13382  
29 April 2014

**ADDENDUM TO RESPONSE TO SUBMISSIONS SSDA6 - SSD 13\_6116  
SICEEP – ICC HOTEL**

We refer to the Response to Submissions (RtS) submitted to Planning and Infrastructure on 26<sup>th</sup> March 2014 in relation to the International Convention Centre (ICC) Hotel (SSDA6).

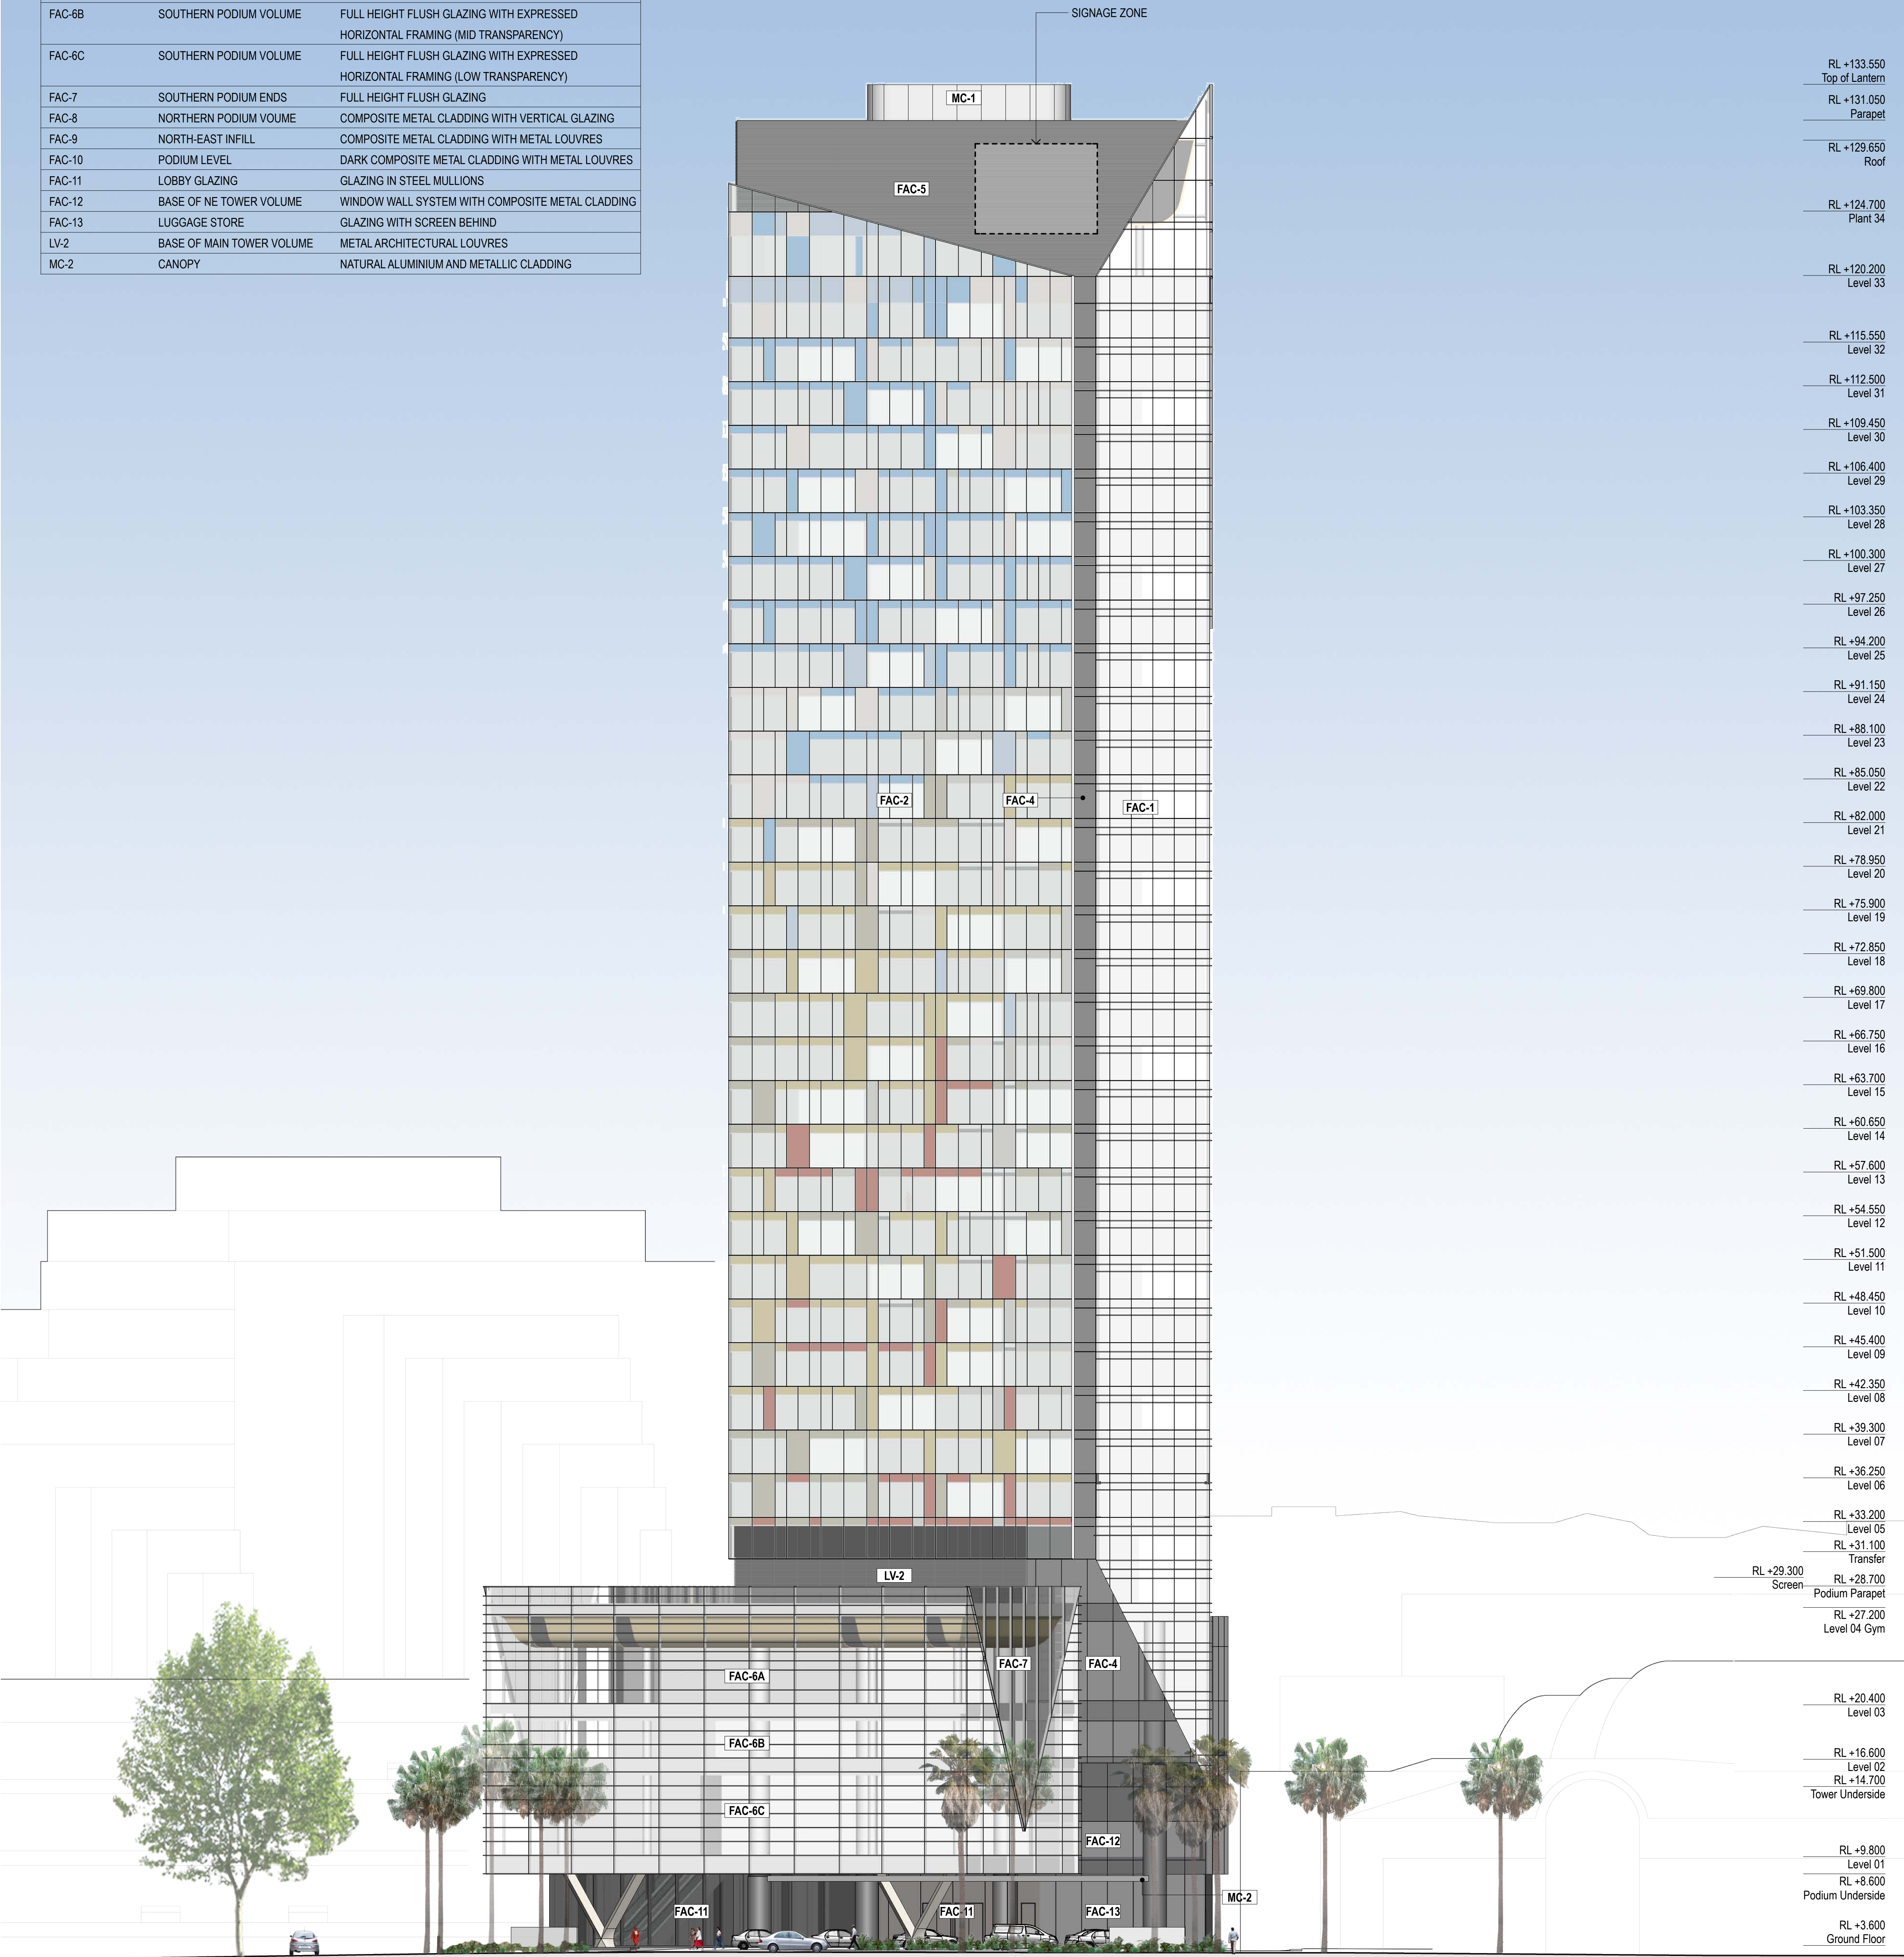
With further consideration of comments raised during the public exhibition period, Lend Lease has made amendments to the building height of the Hotel tower (reducing the height of the tower by 3 storeys). This change addresses comments raised by the general public and the City of Sydney Council, where concern was raised in relation to overshadowing impacts on the public realm.

Component	Amended Proposal	Change from RtS
Gross Floor Area (max)		
■ Overall	37,090m <sup>2</sup>	Decrease of 2,850m <sup>2</sup>
■ Guest and visitor facilities / common areas (front of house)	5,075m <sup>2</sup>	No change
Height		
■ Metres	RL133.55	Decrease of 9.15m
■ Storeys	35 storeys	Decrease of 3 storeys
No. of keys	Up to 616	Decrease of 40
No. of car spaces	7 short-term spaces	No change
No. of Bus spaces	2	No change
Bicycle Parking	15 internal 12 external within the public domain	No change
